Application Reference: Y/9/25/DOC Site Name: Fleurie Nursery Lake Lane Barnham PO22 0AL	Initial Issue Date: 21/02/2025 Issue Date: Reviewer Reference: ADC/SB
--	---

Summary and Recommendation:

Condition 4: **Objection**
Condition 5: **Objection**
Condition 6: **Objection**

CONTRIBUTING AREA PLAN (1:200)

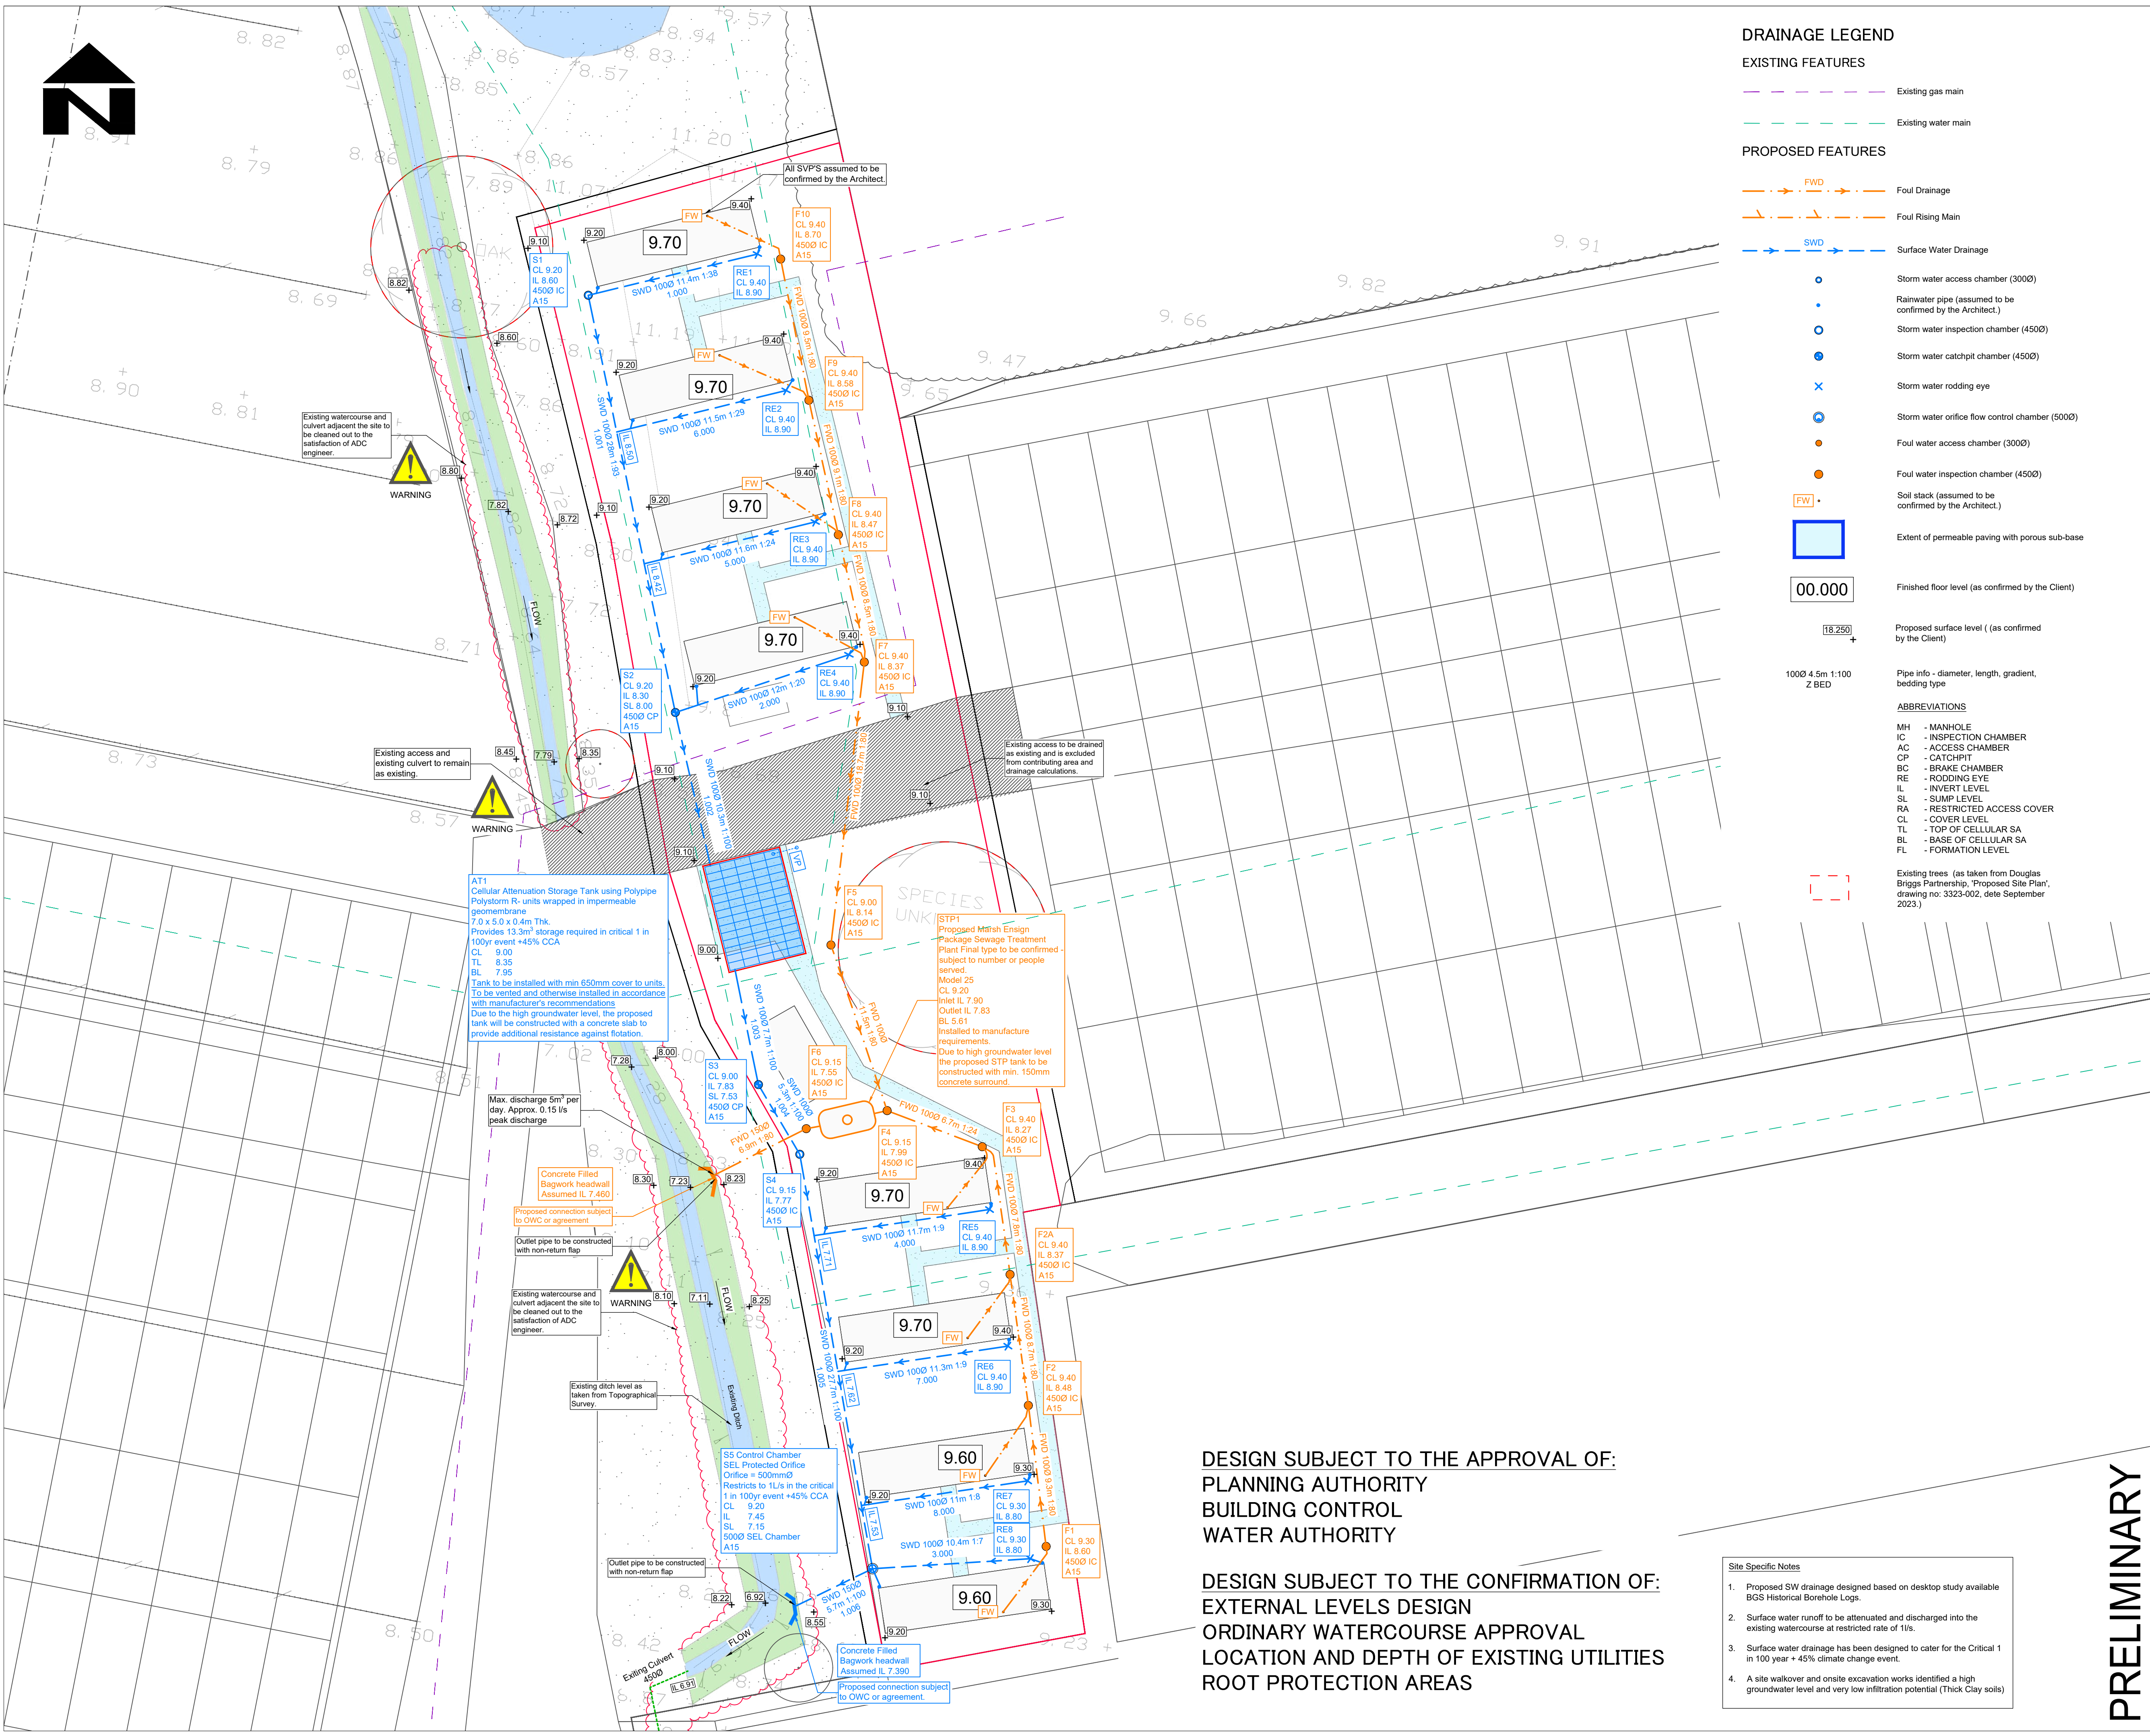
5.	Please correct the impermeable area contributions in the modelling. Currently less than described on the plan due to rounding down. The southern areas are also shown entering the system at S4 which is an inaccurate representation. If grouped together then they should be showing as entering at S5.	Please find the updated drainage calculations attached with impermeable areas being added to drainage nodes.

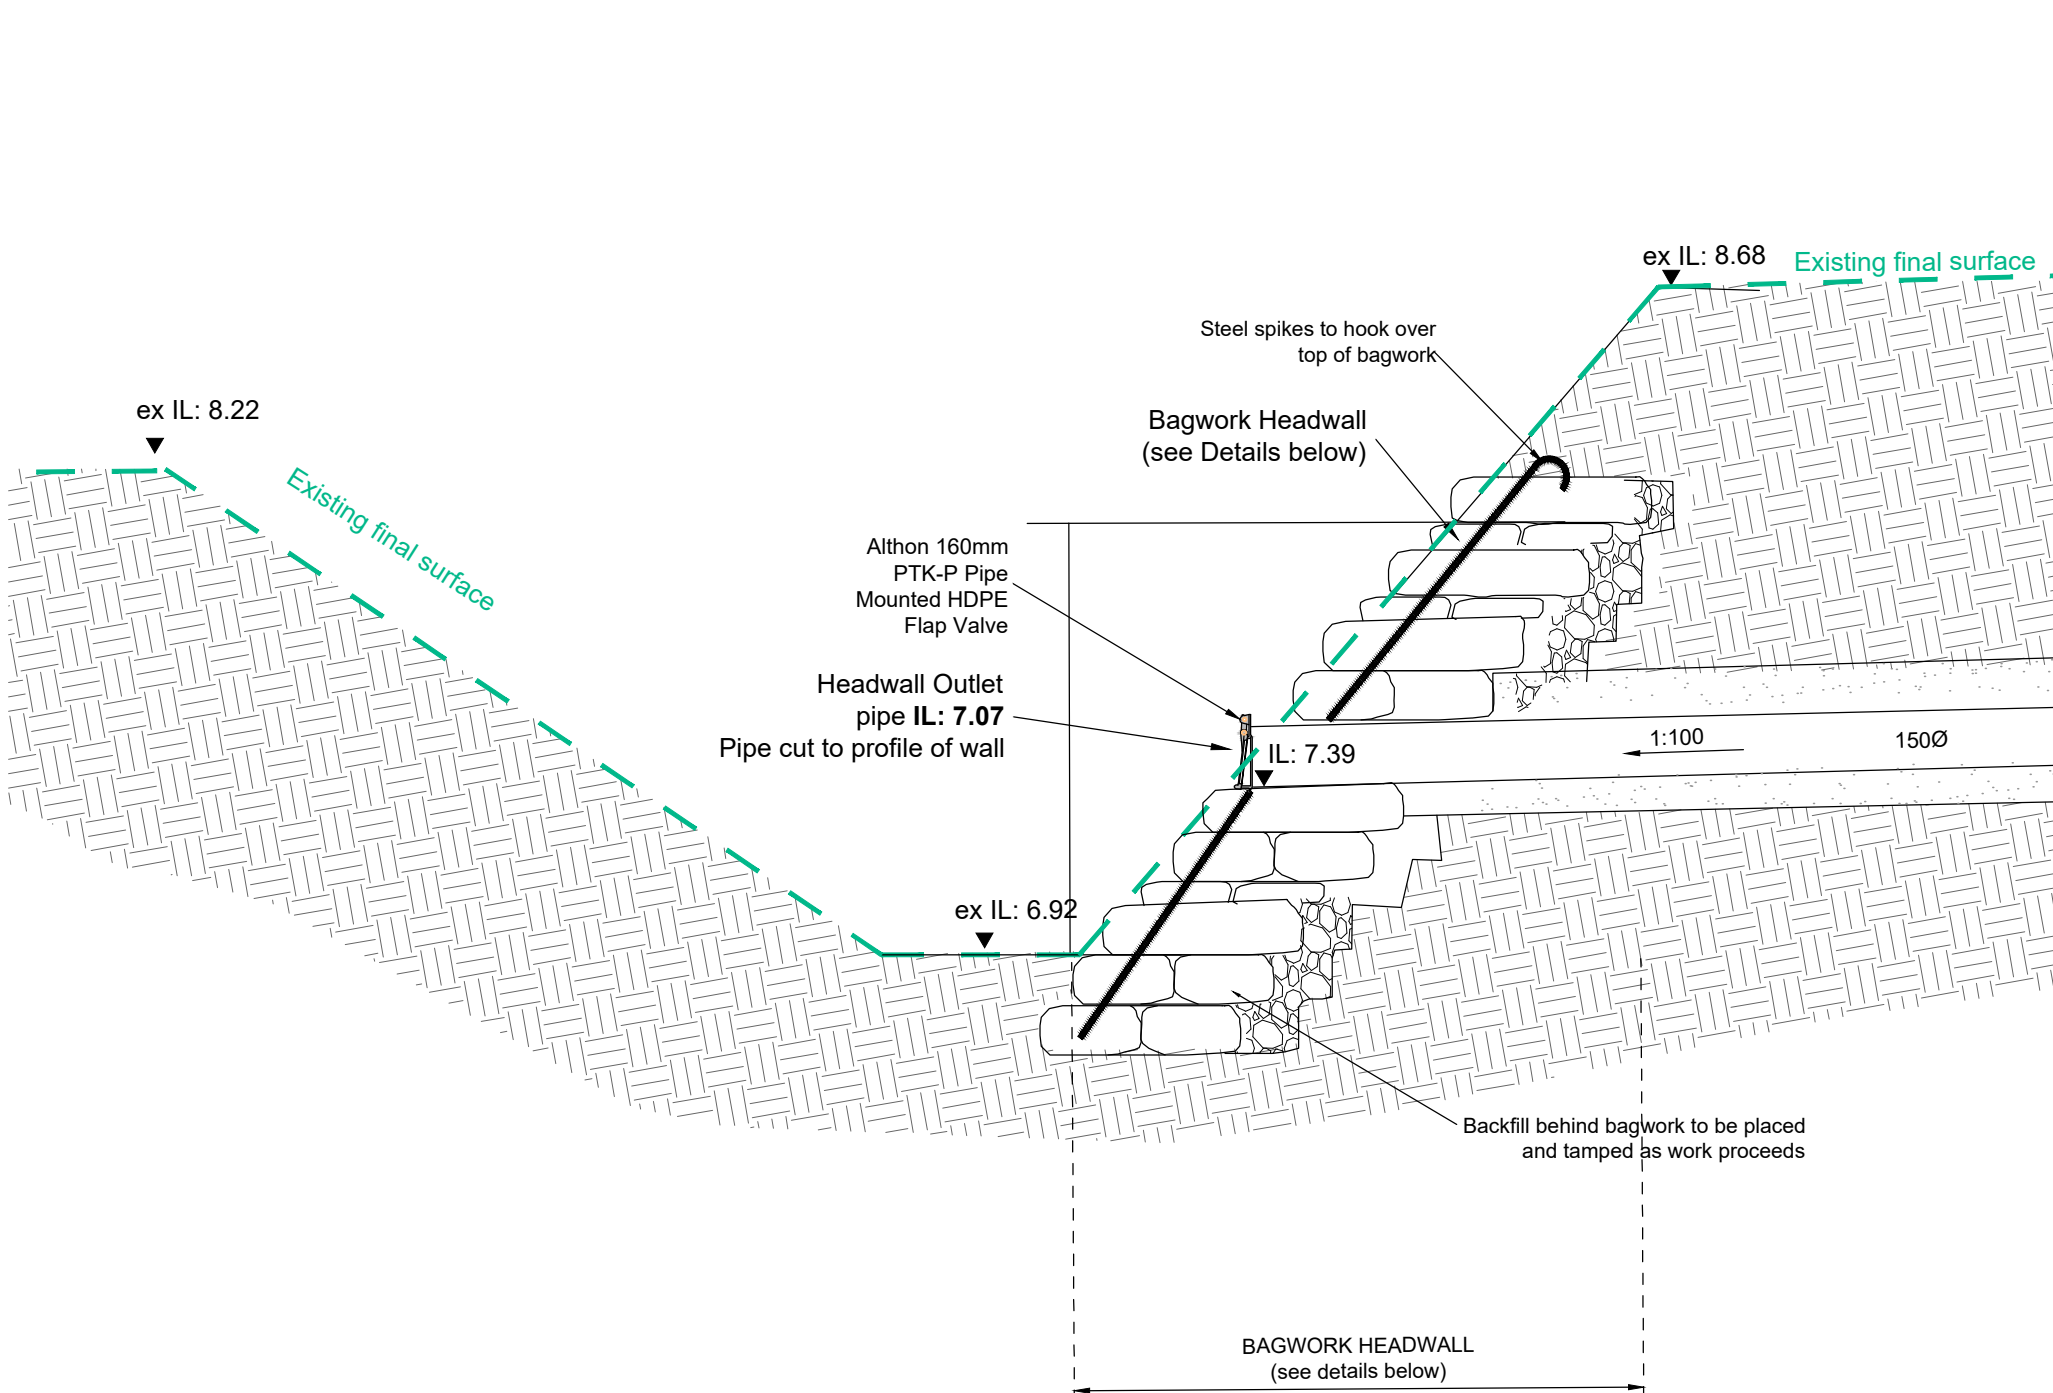
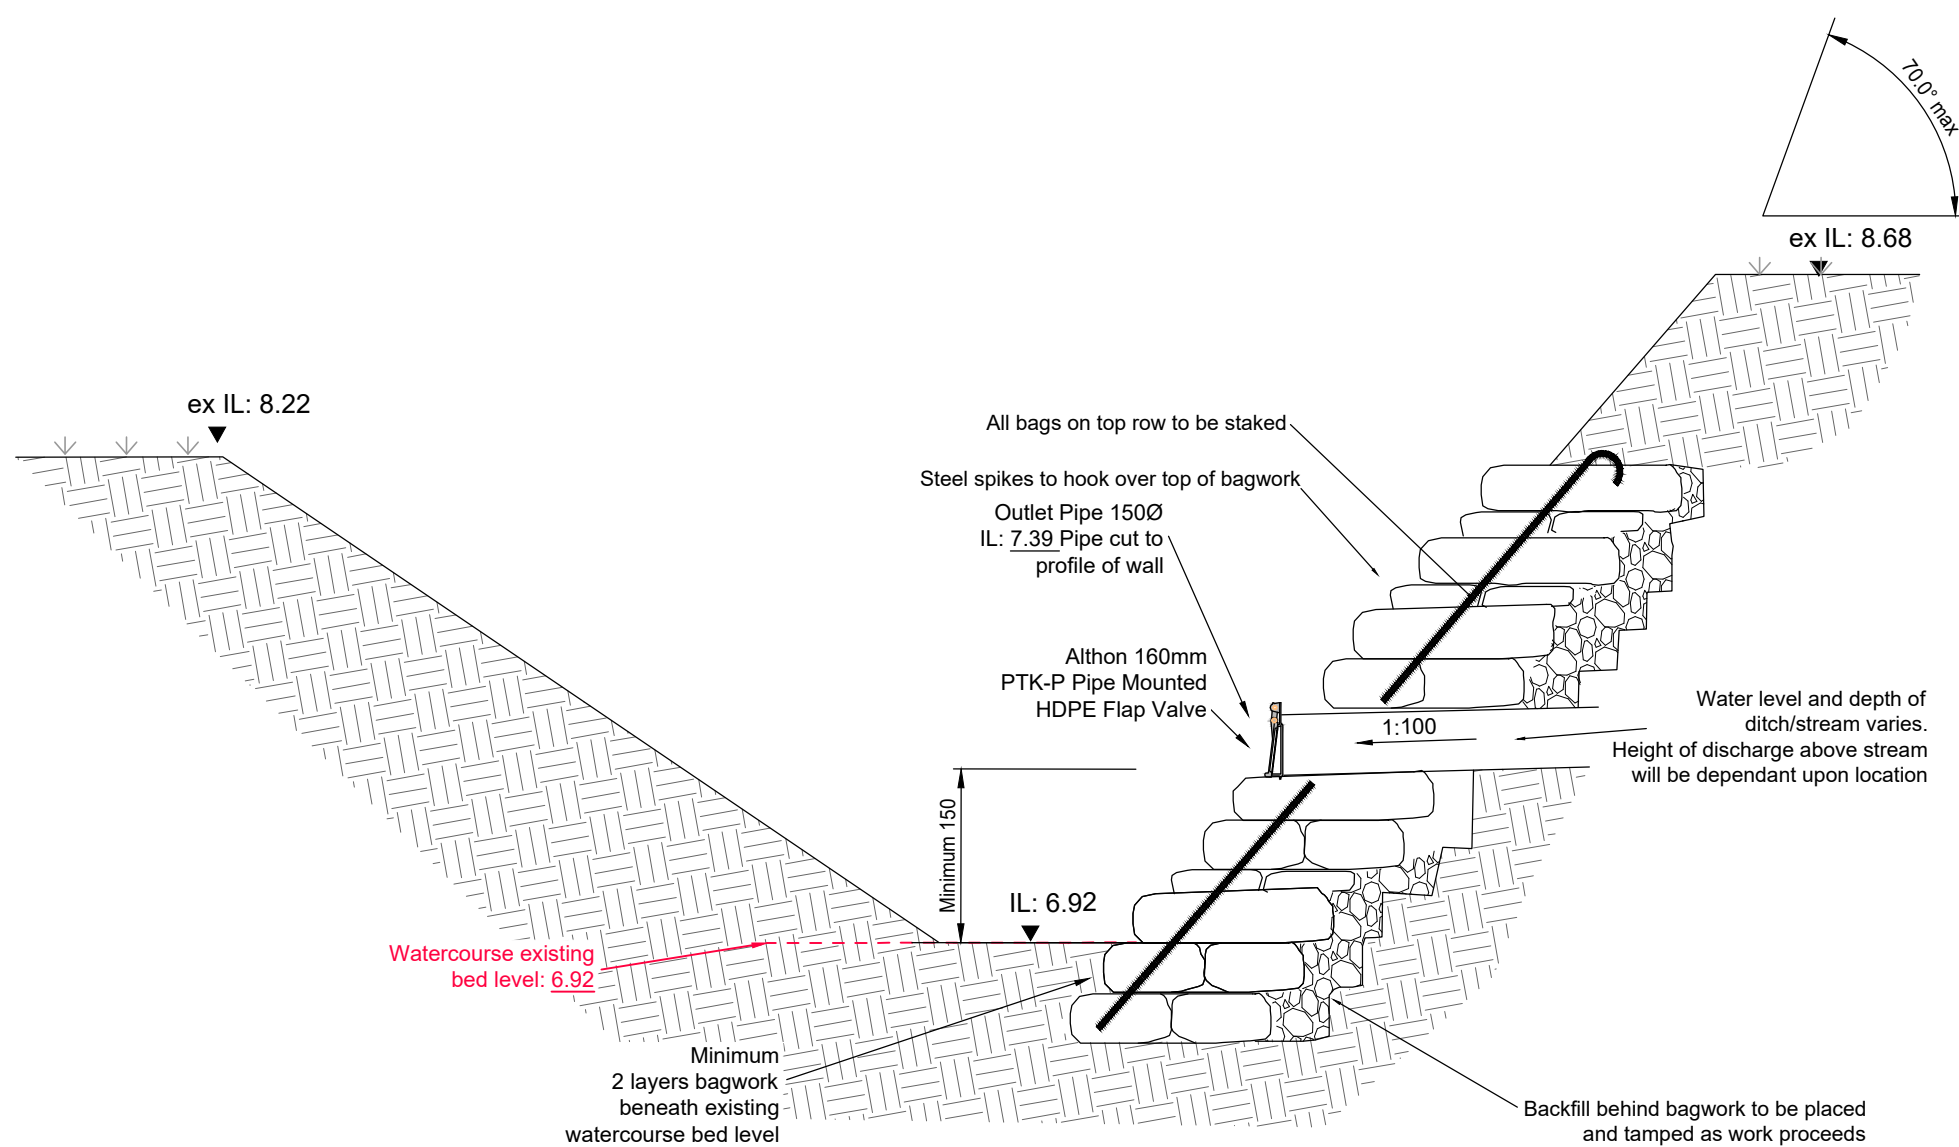
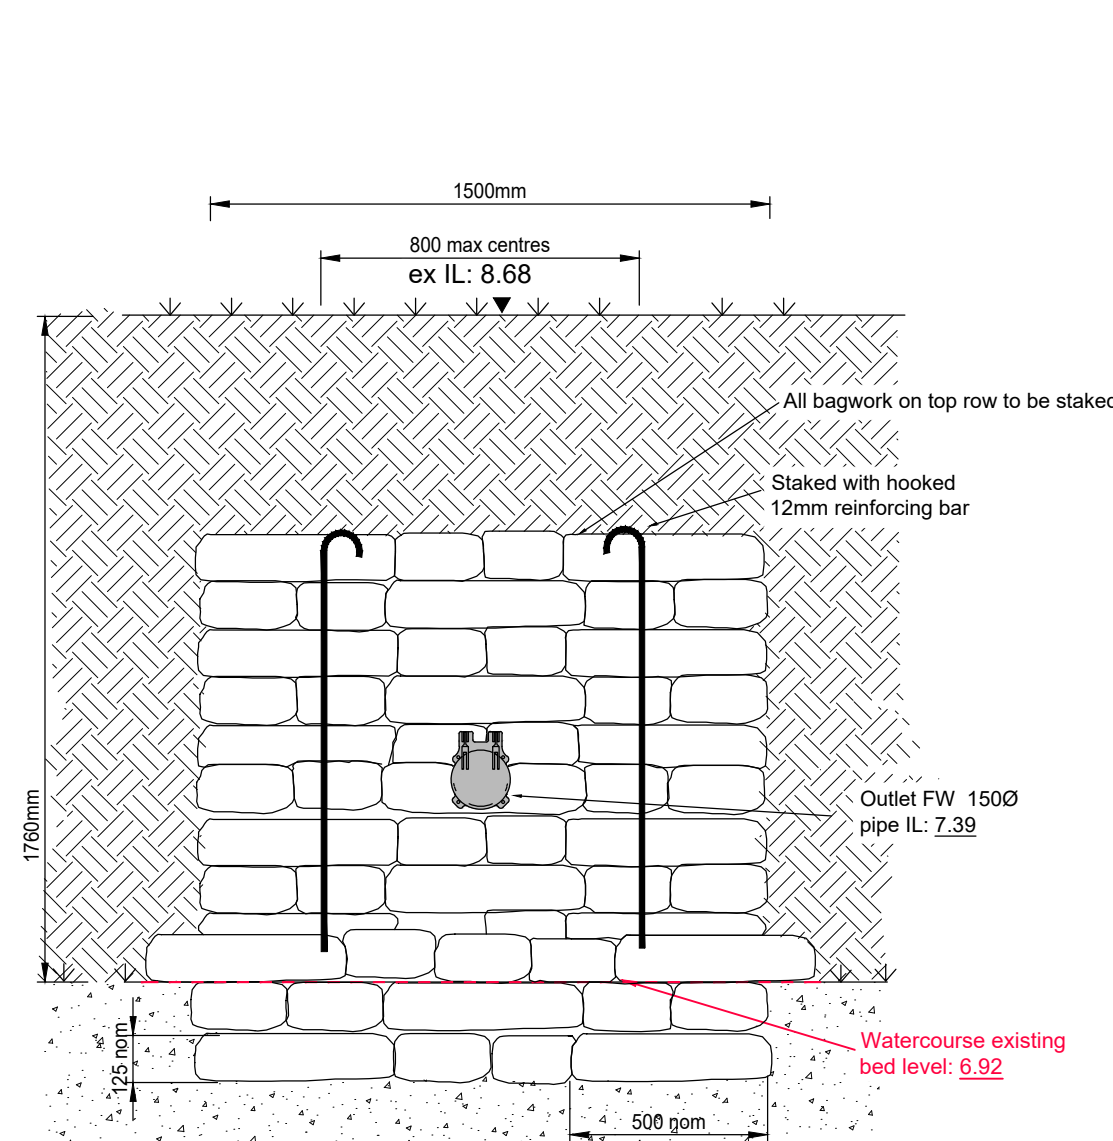
12.	The modelling does not include the flap valve.	Flap Valve is now included			
13.	Please remove the standard (non-site specific) headwall details from C2904-P-501. These contradict the OWC drawings which are more detailed and site specific.	Headwall detail has been removed It should be noted that OWC drawings have been issued and comments have been received. Drawings are now updated and the updated drawings has been issued for final review.
